Planning Applications

- 1.1 Change of Use to office/business (B1) and Financial and Professional Service (A2). Application No 2012/0328
- 1.2 A meeting was held on 14.03.2012 to discuss the above application together with the case officer Steve Kirkham and the historic buildings officer Tony Wiles.

- 2.1 Listed Building Consent, Internal Alterations
Application No 2012/0333/INVALID

Project: FORMER COUNTY COURT BUILDING 12 REGENTS STREET, BARNESLEY		Client: LUDY'S SOLUTIONS
Drawing Title: FIXED FURNITURE REMOVED PLAN		Date: MARCH 2012
Scale: 1:100 @A1		Dwg. No. 01
Rev. 01

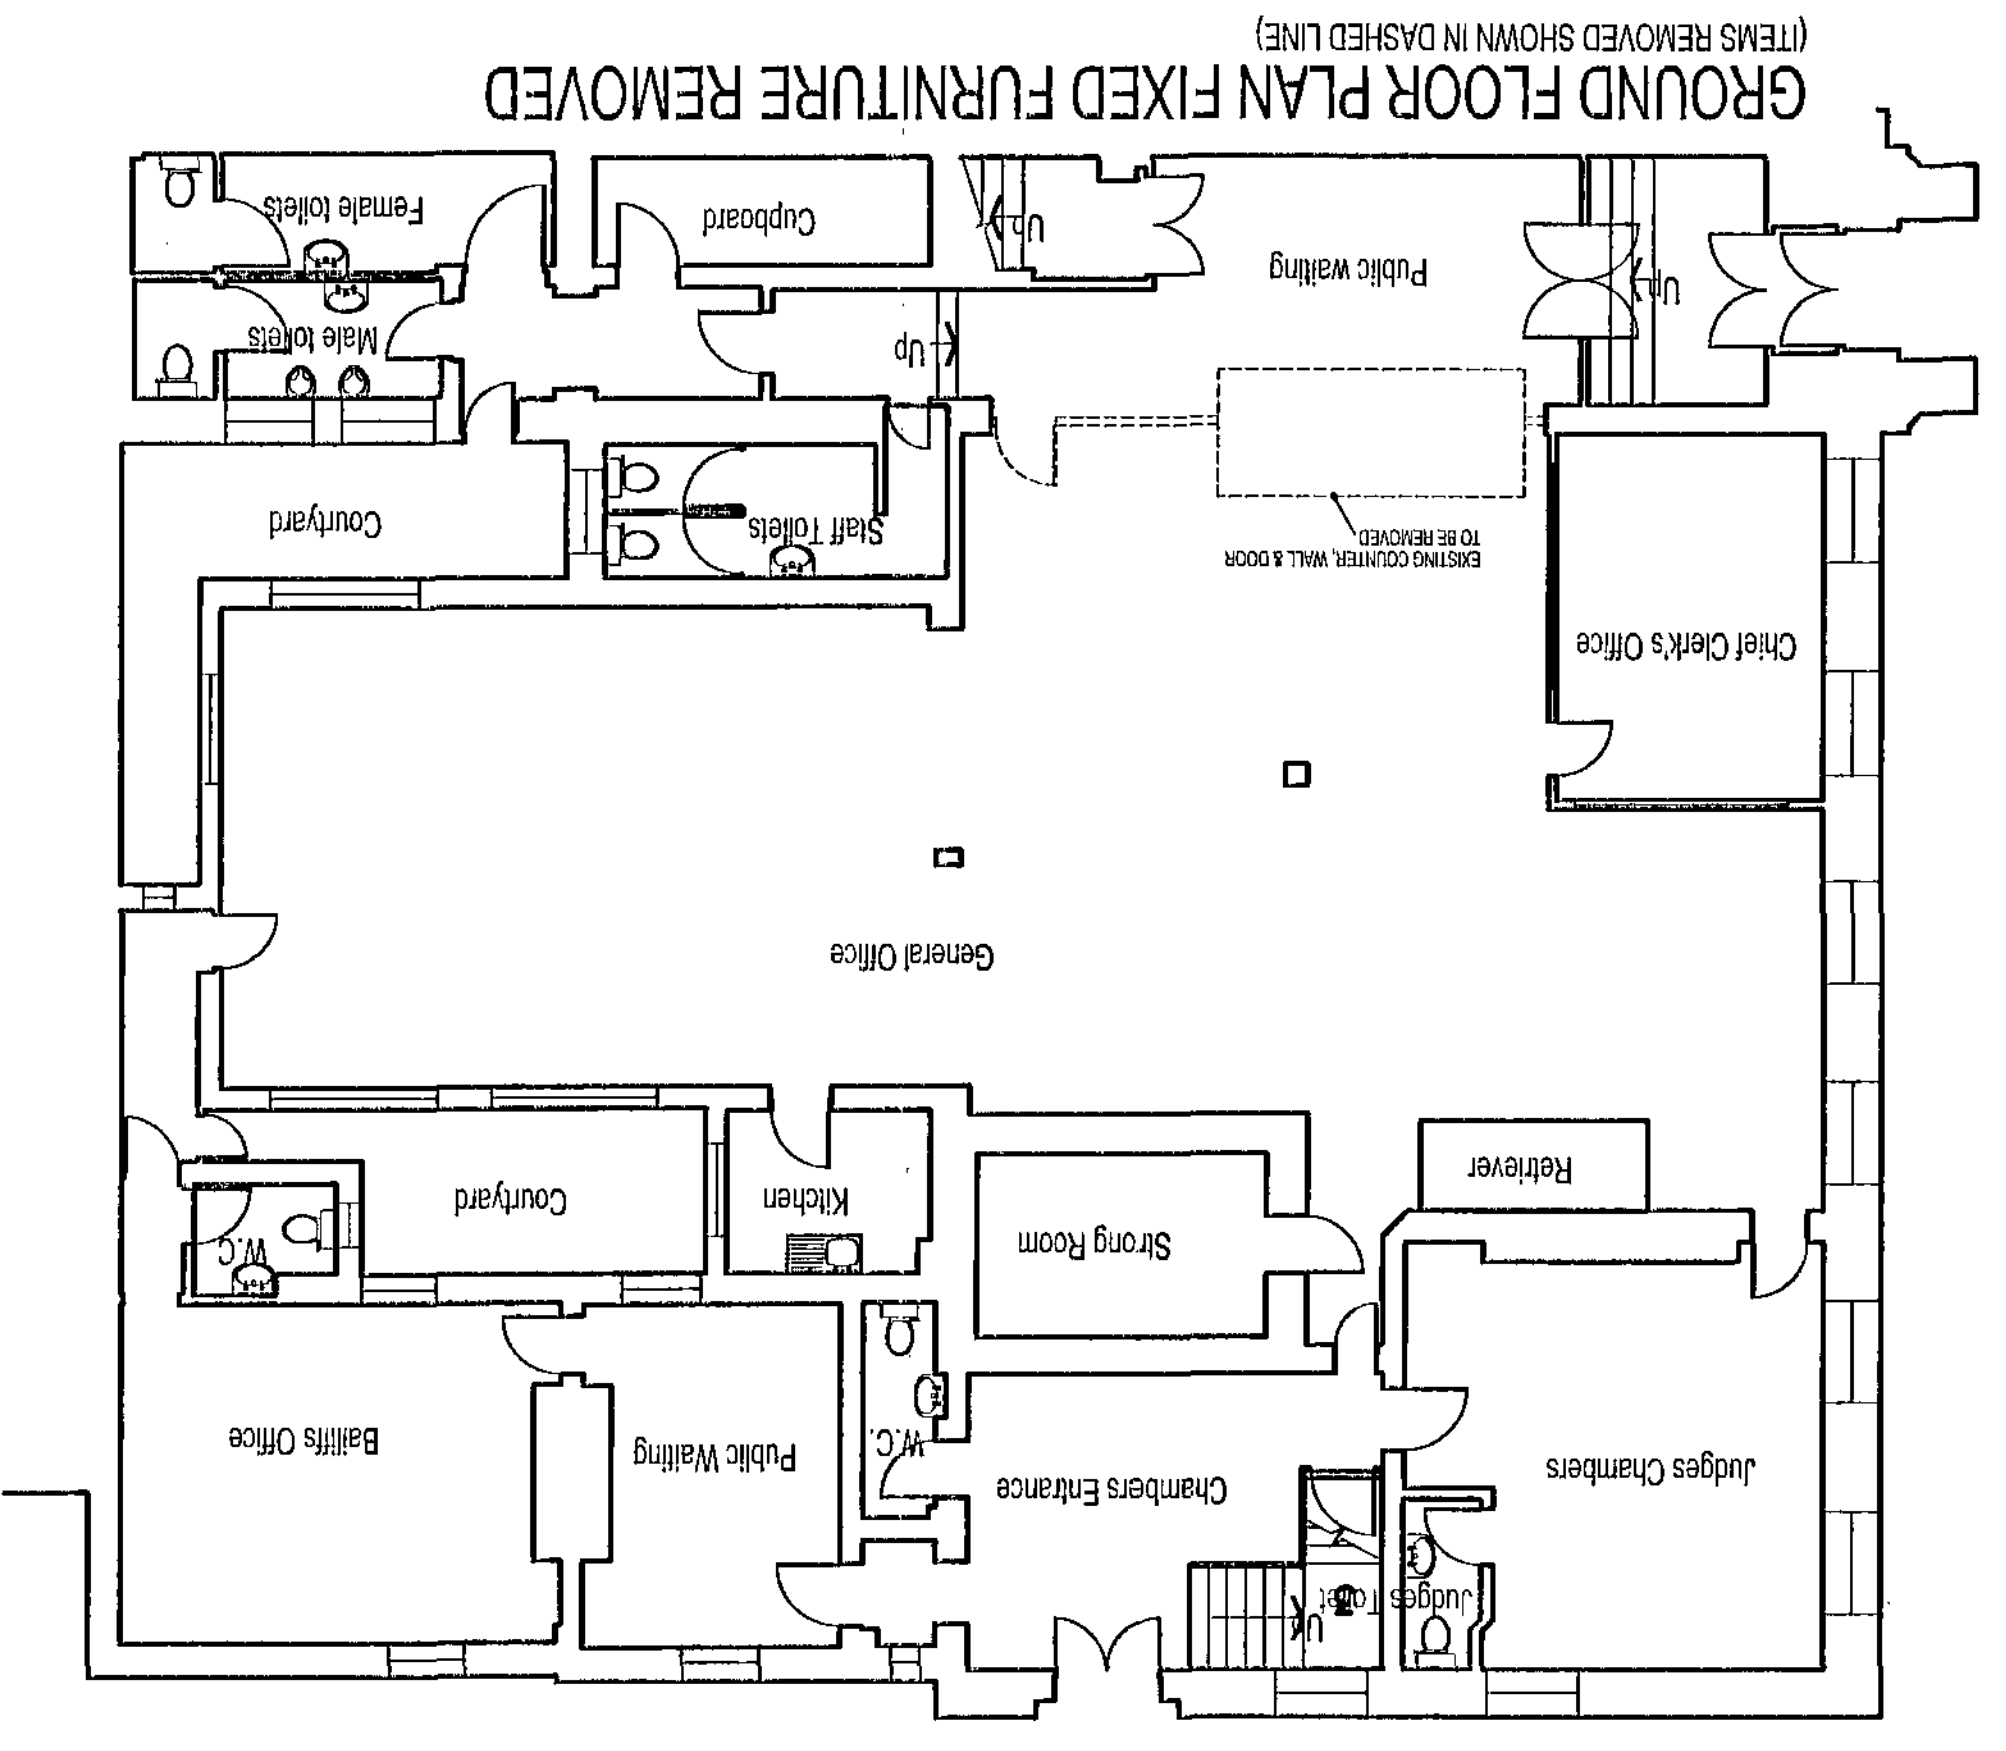
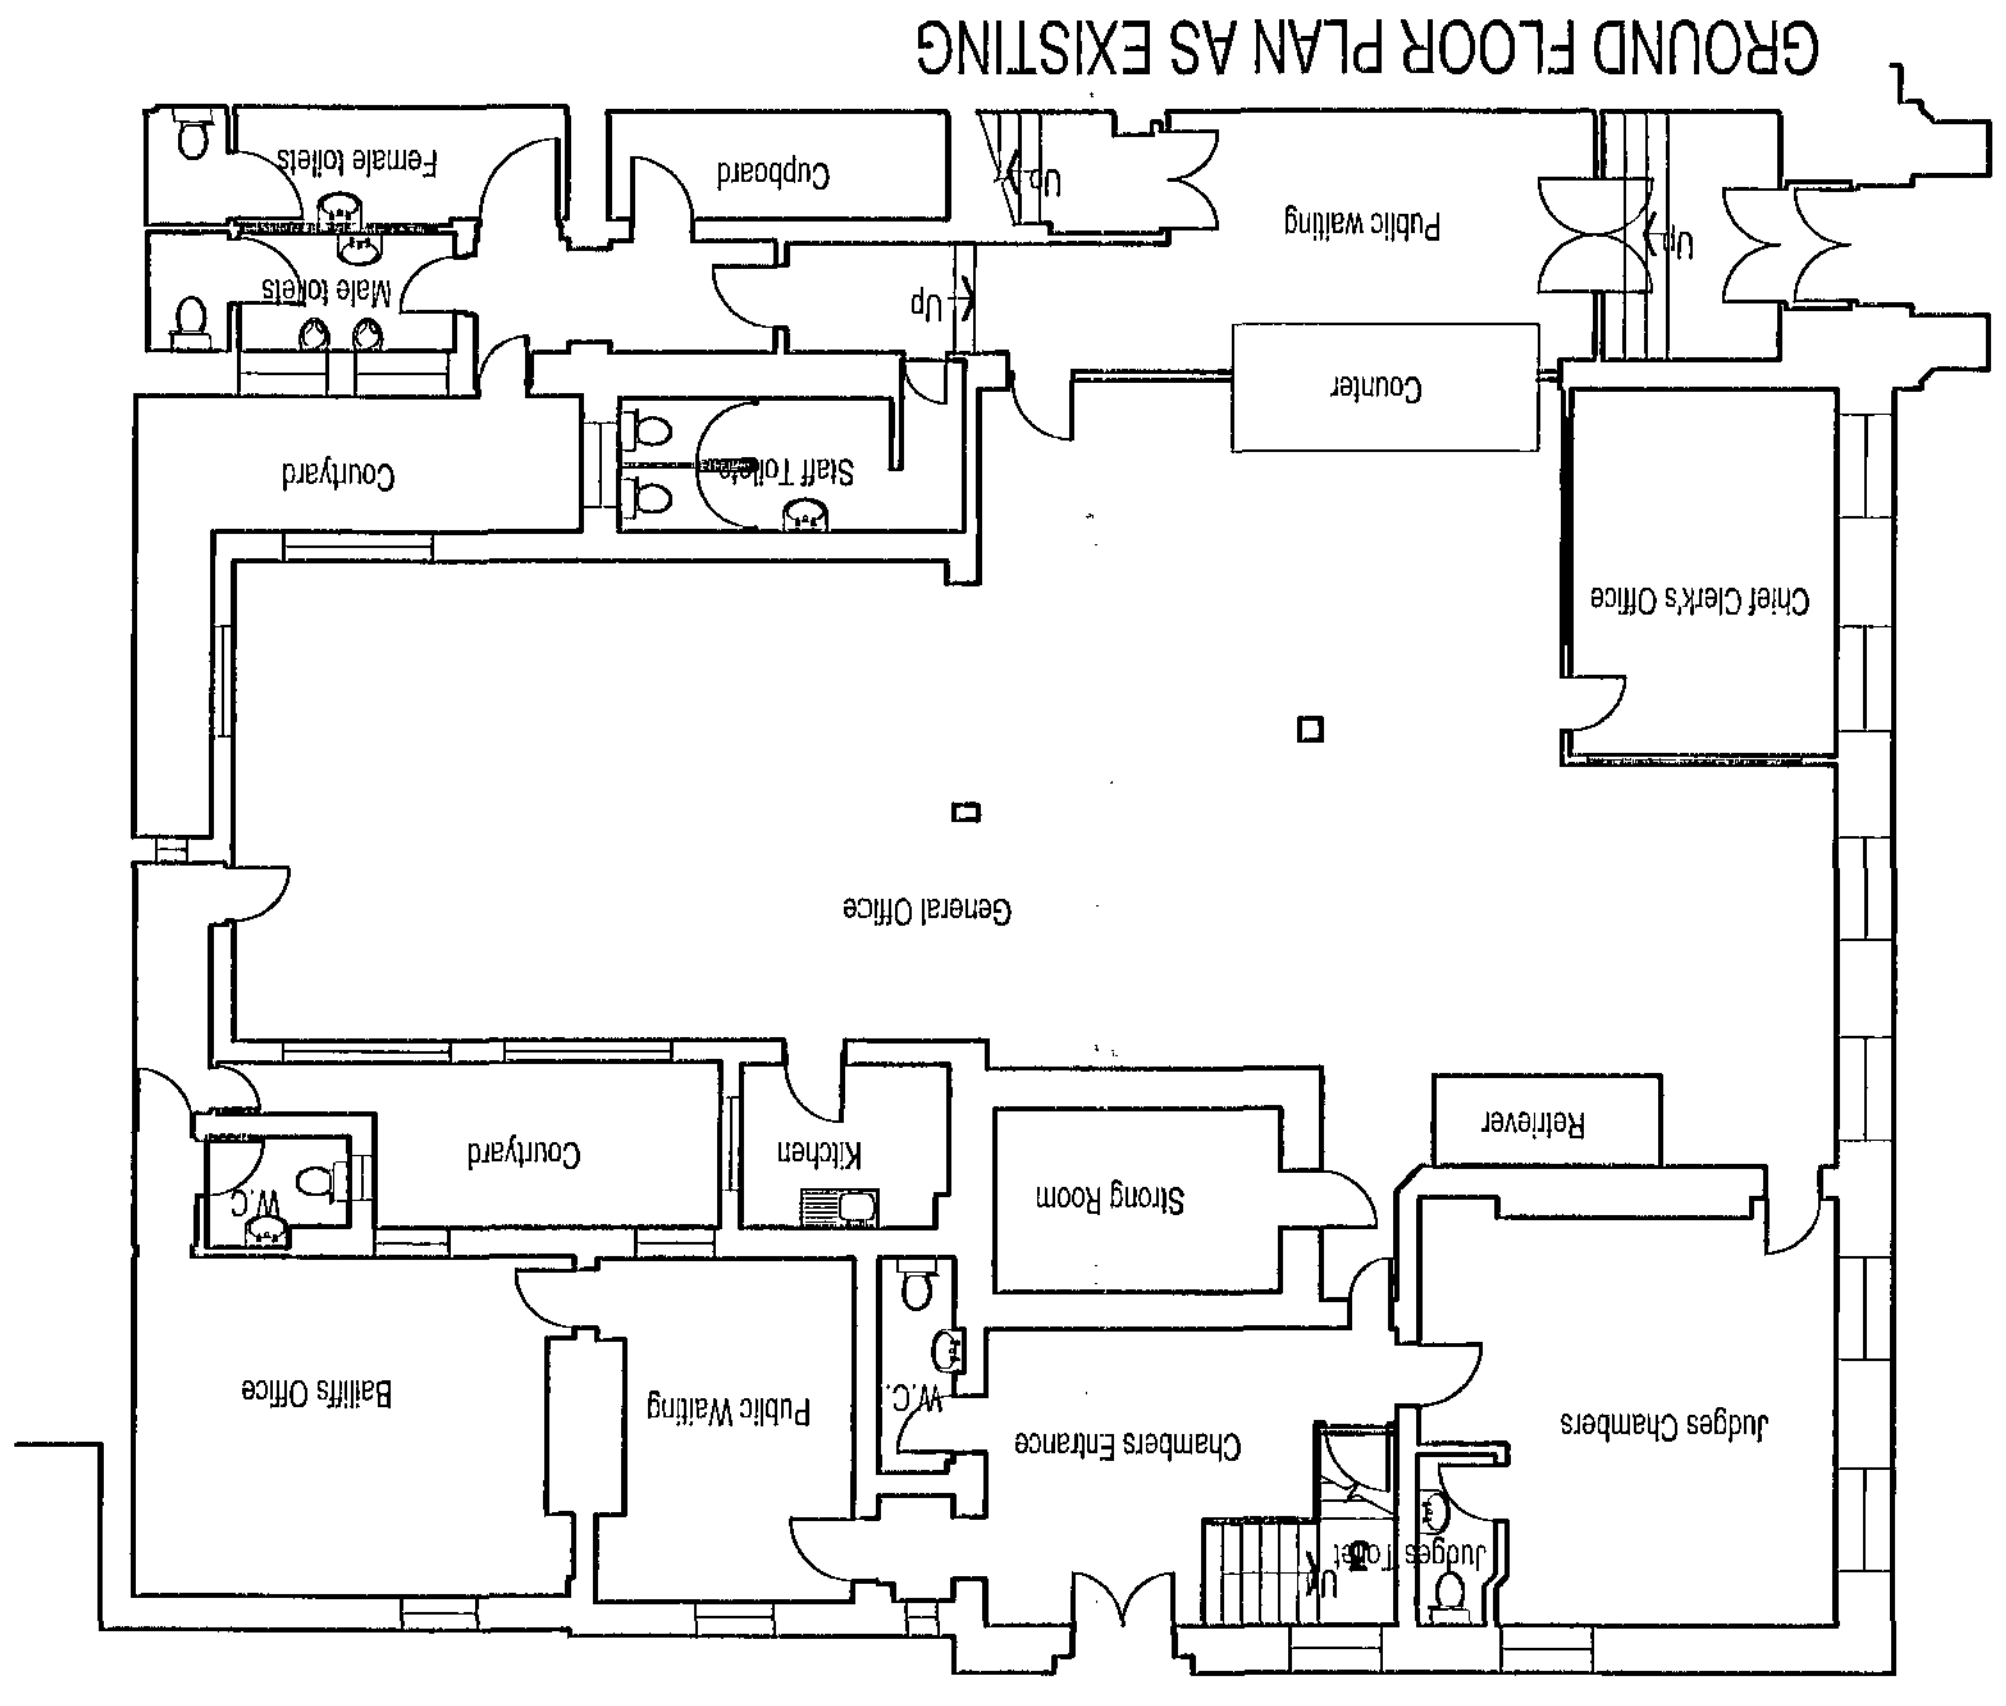
2.4 Further plans are to be prepared and submitted to show the changes to the fixed furniture (removal) within the courtroom and the removal of raised floor levels.
